DELEGATED DETAILS DECISION

Report of the Head of Planning, Building Control, Sport & Green Spaces

Address 37 ST JOHN'S ROAD UXBRIDGE

Development: Details pursuant to conditions 3 (Materials), 16 (Landscape Scheme) and 20 (Footpath) of planning permission Ref: 15811/APP/2014/2444 dated 6/02/2014 (4 x 2-storey, 3-bed, semi-detached houses with habitable roofspace and 3 x two storey, 3-bed, detached houses with habitable roofspace with associated parking and amenity space involving demolition of existing B1 office building)

DRAWN BY
Claire Pollard
DESCRIPTION
Proposed Planting Plan
Scale 1:50 @ A1

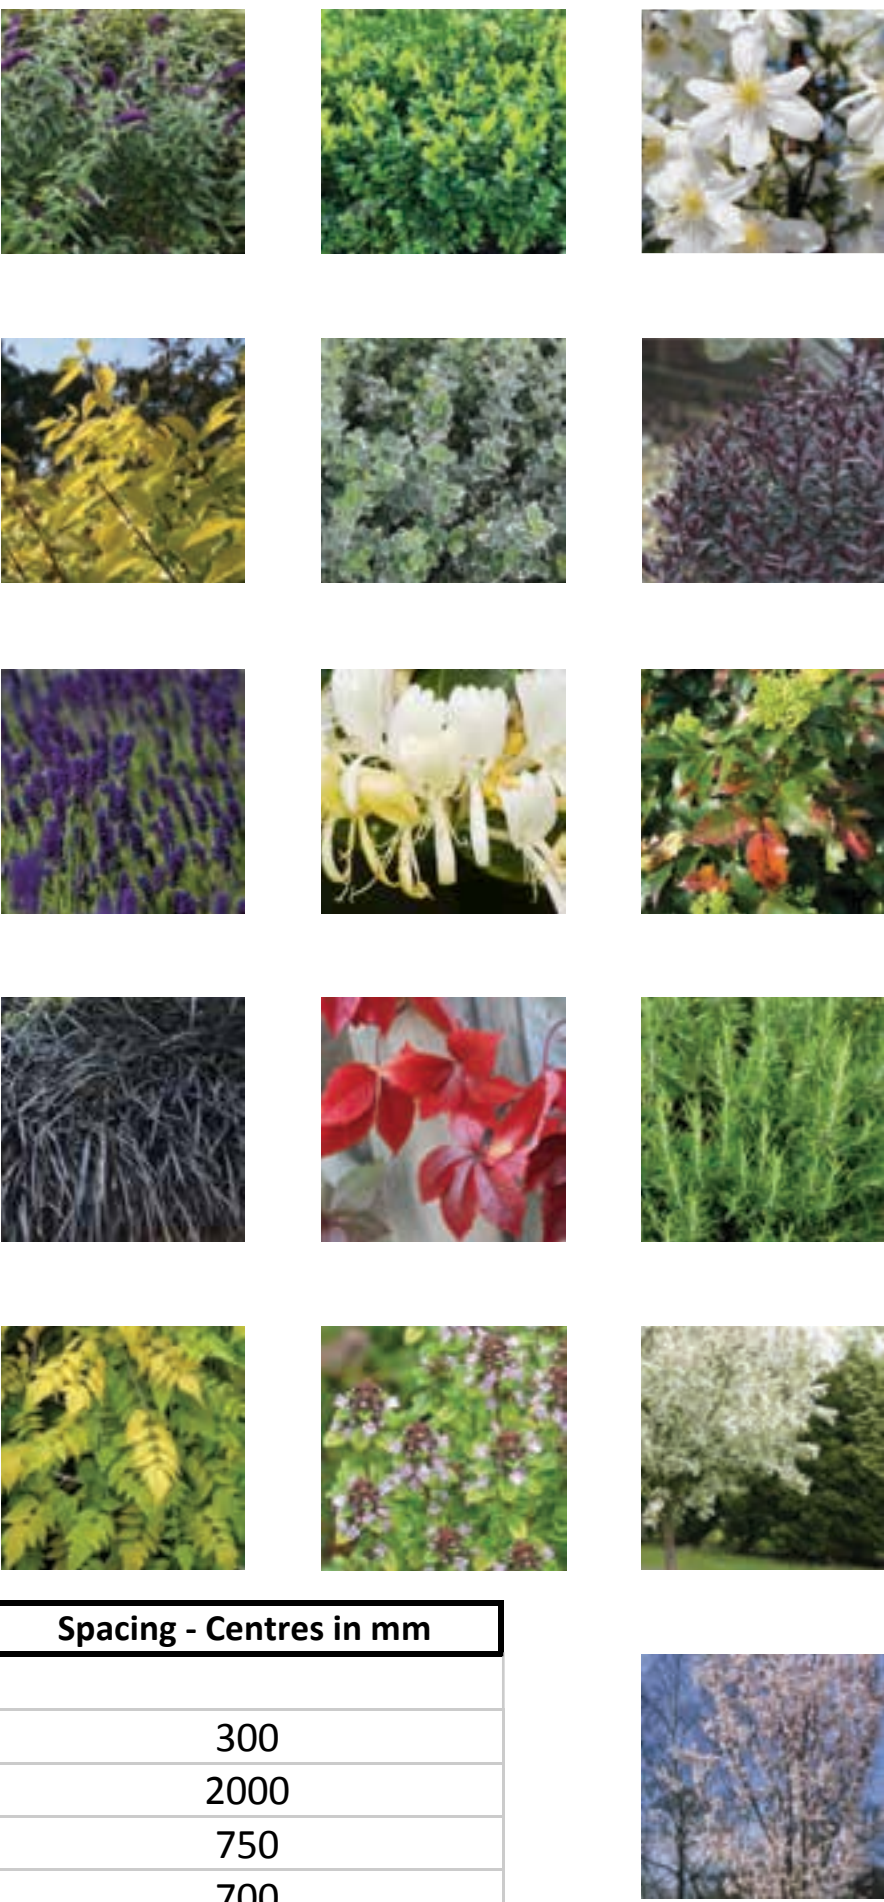
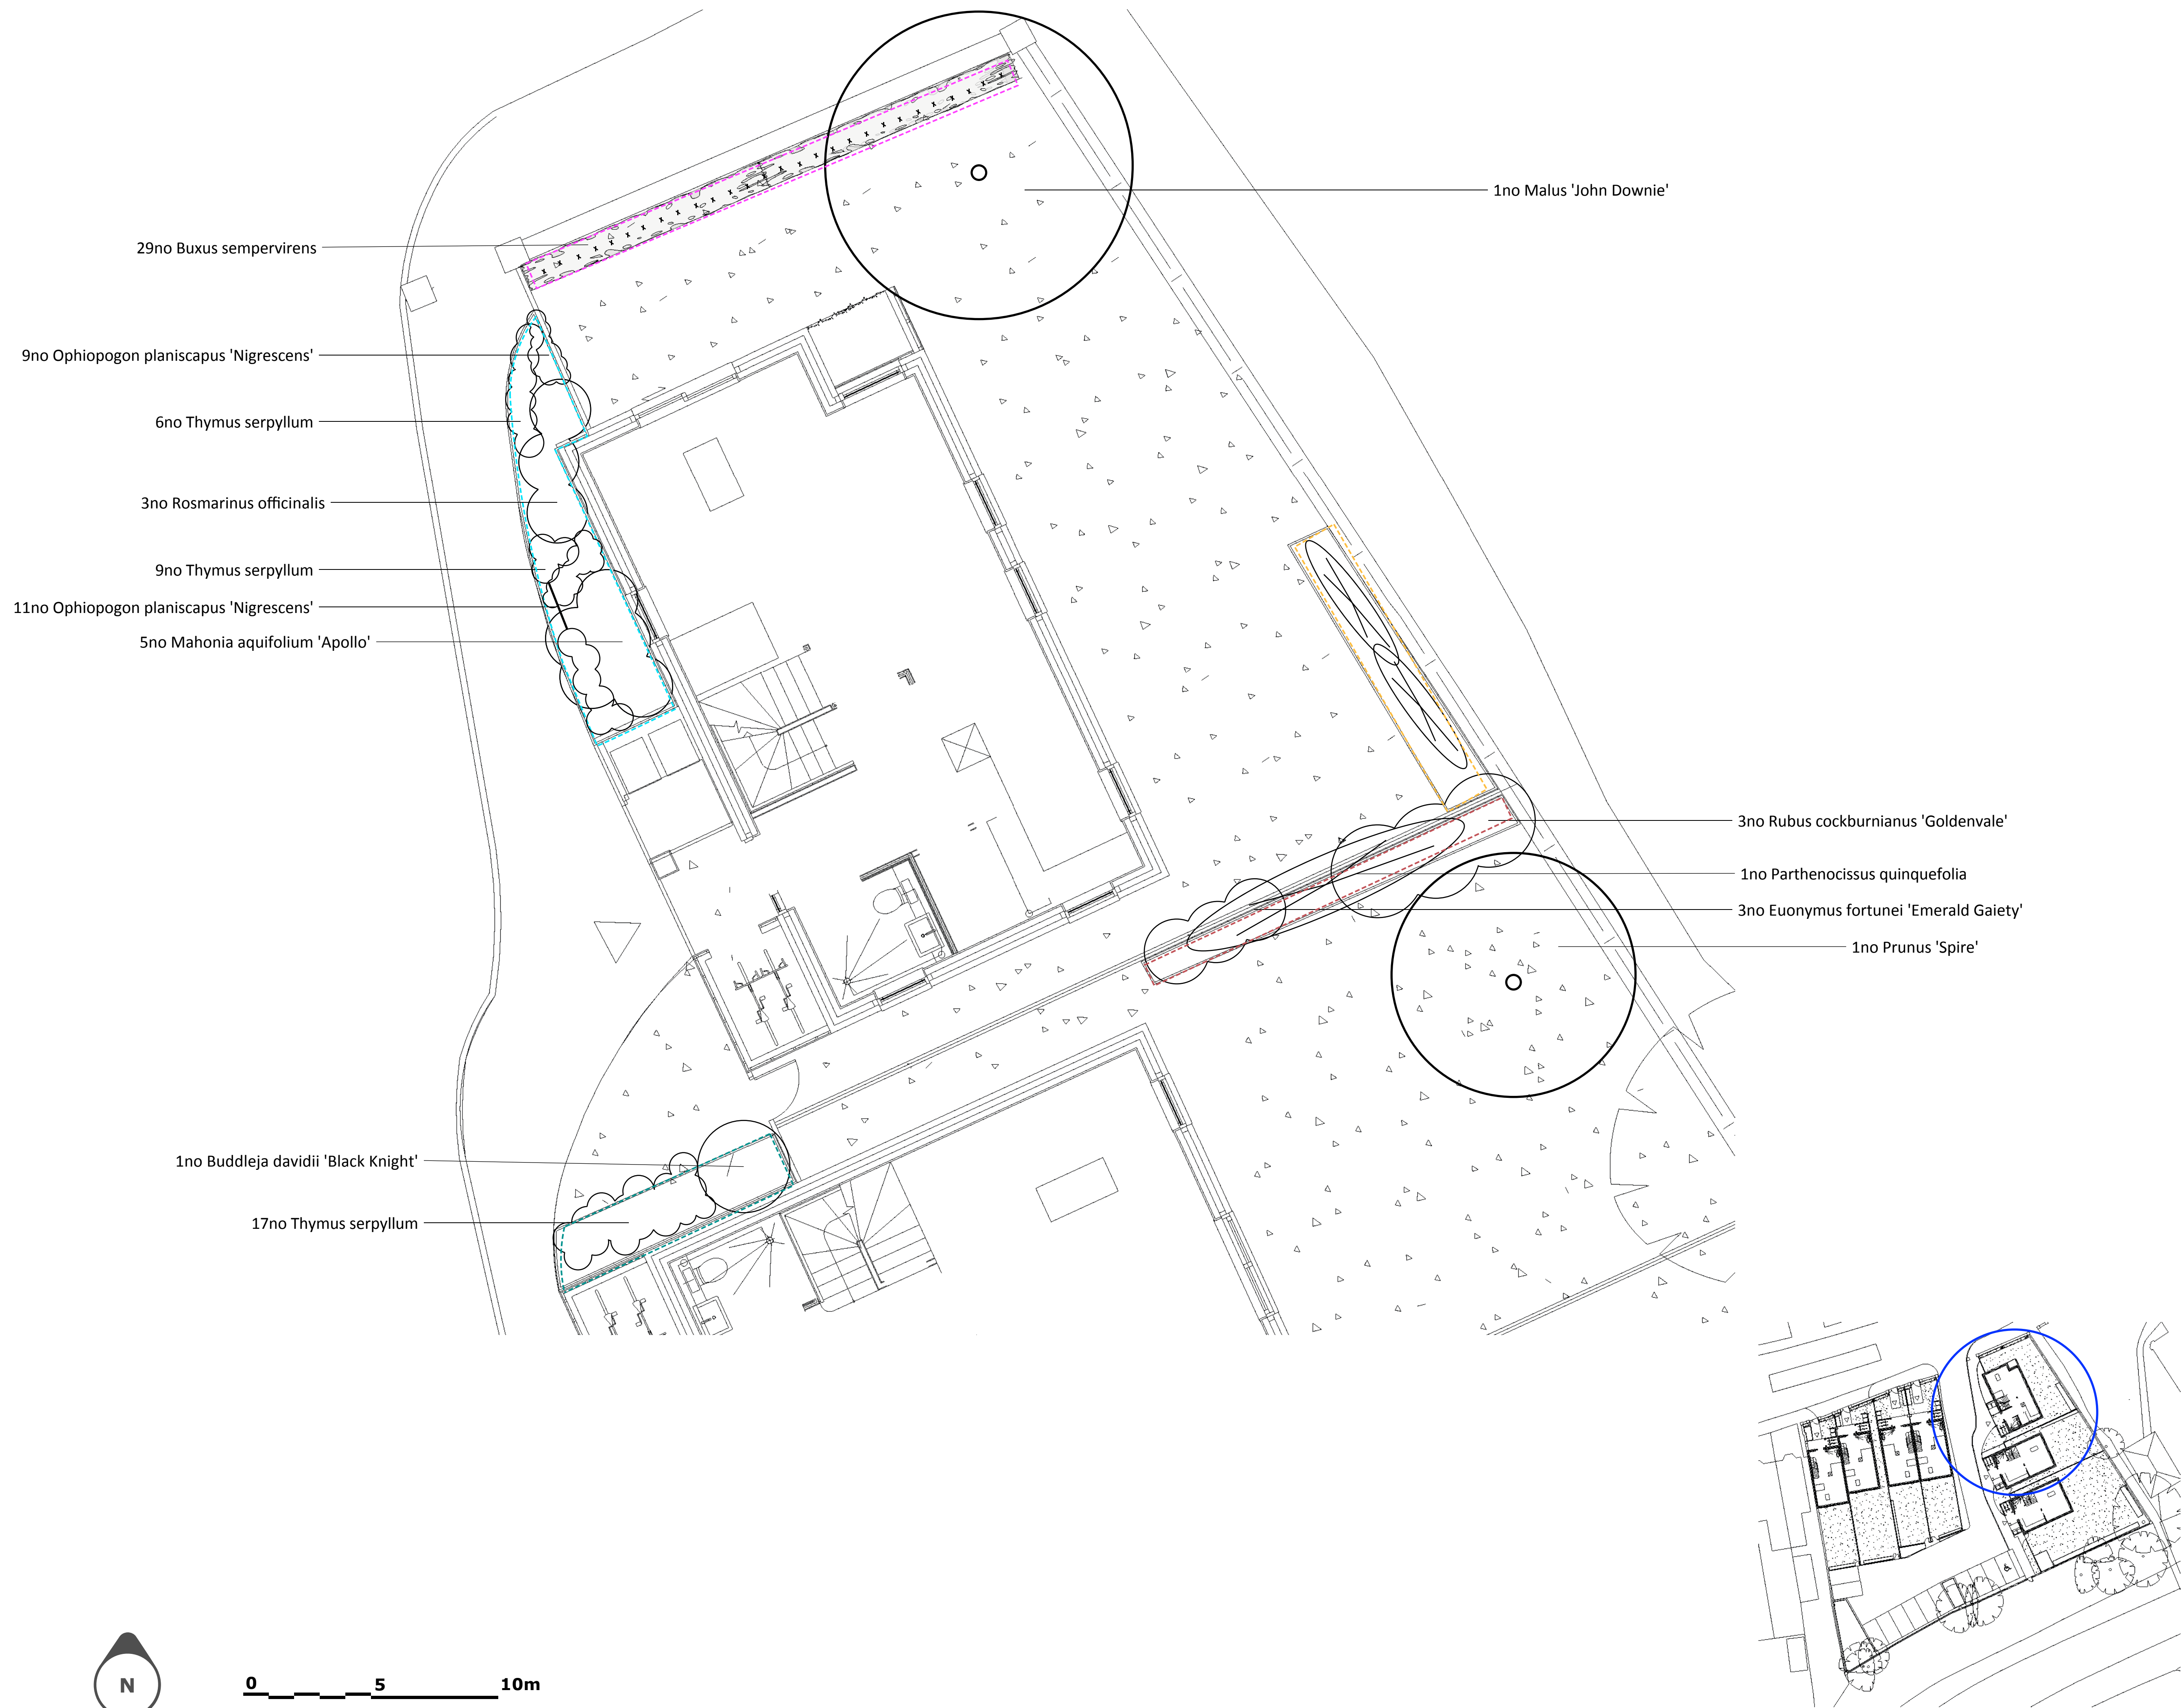
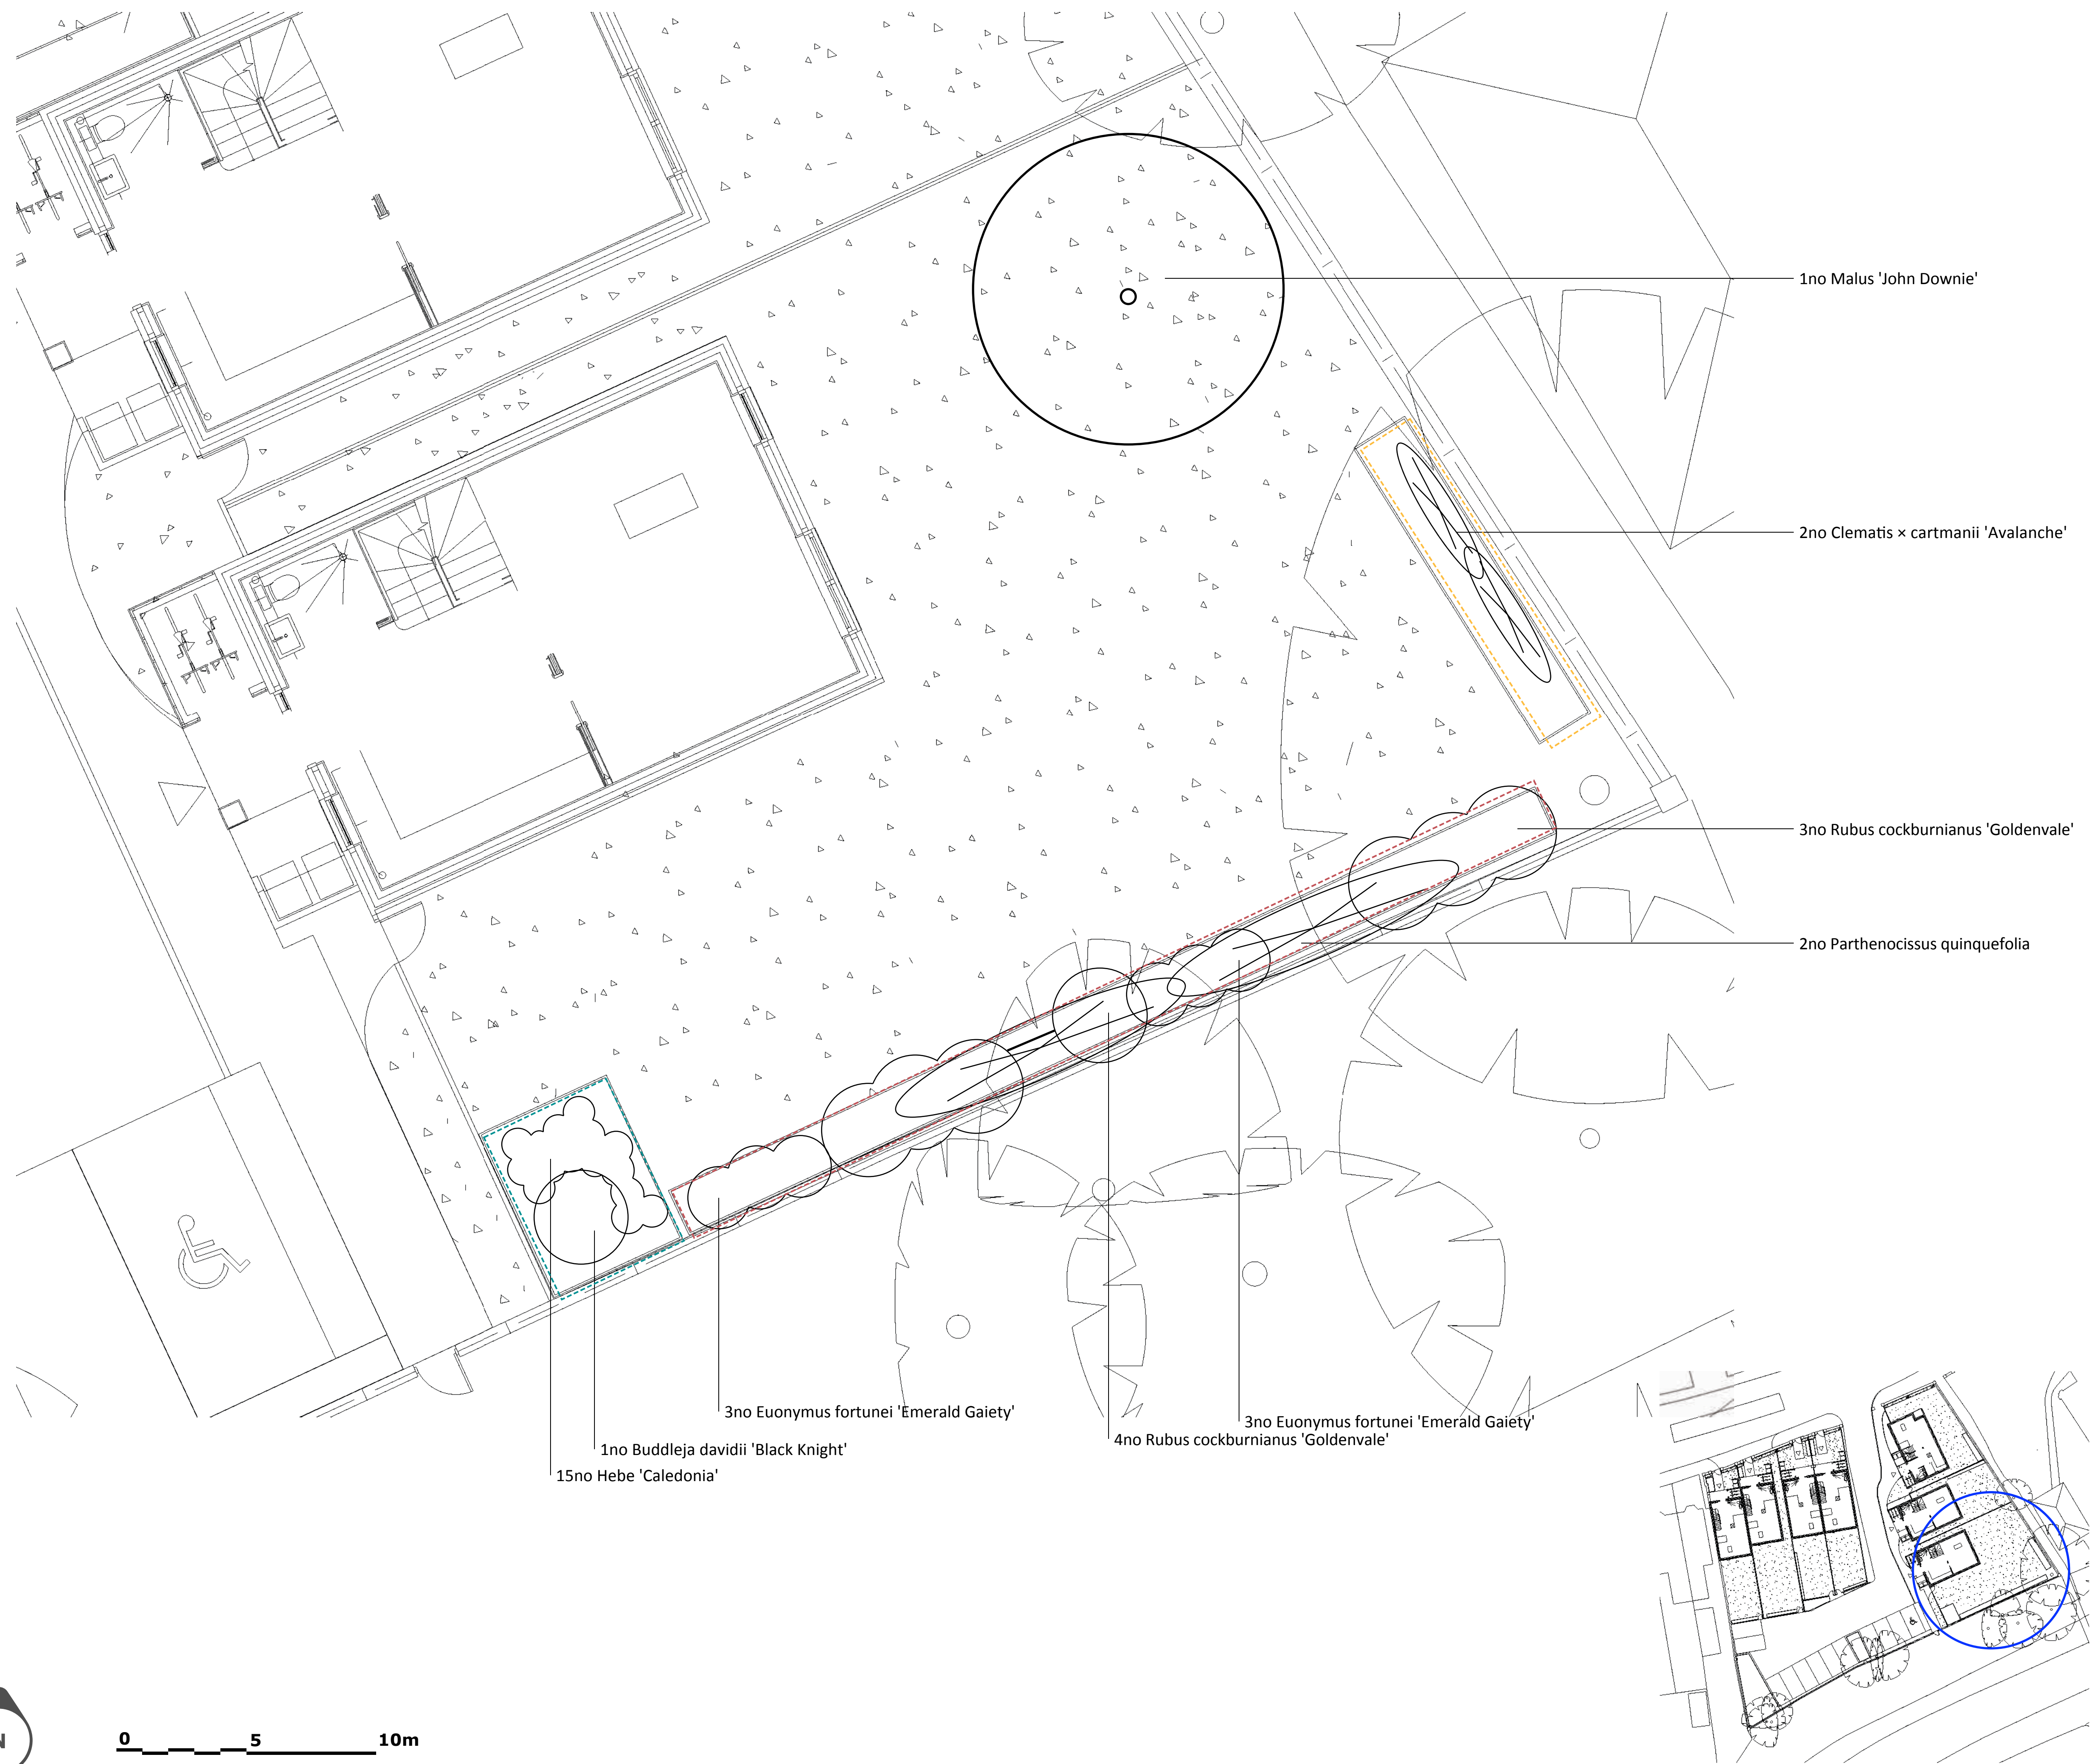
Condition 16 - Trees & Landscaping Officer: Iron Butterfly's drawing Nos. 1-6 provide planting plans and schedules for the development. The planting includes 7No. new trees and a range ornamental shrubs and groundcover which are suitable for a residential area. The planting plan is supported by a Landscape Specification and a Landscape Maintenance and Management Plan.

· The Management Plan should include a clause to confirm that the health of plants will be checked towards the end of each growing season (August/September) and any plants which fail to establish or subsequently die will be replaced in accordance with the planting plan at the next planting season (November-March)

OFFICER COMMENT: The applicant has since submitted supporting documents which include a management and maintenance plan for the landscaping scheme and specify the type of paving to be used at the site, which is now considered to meet the requirements of the condition.
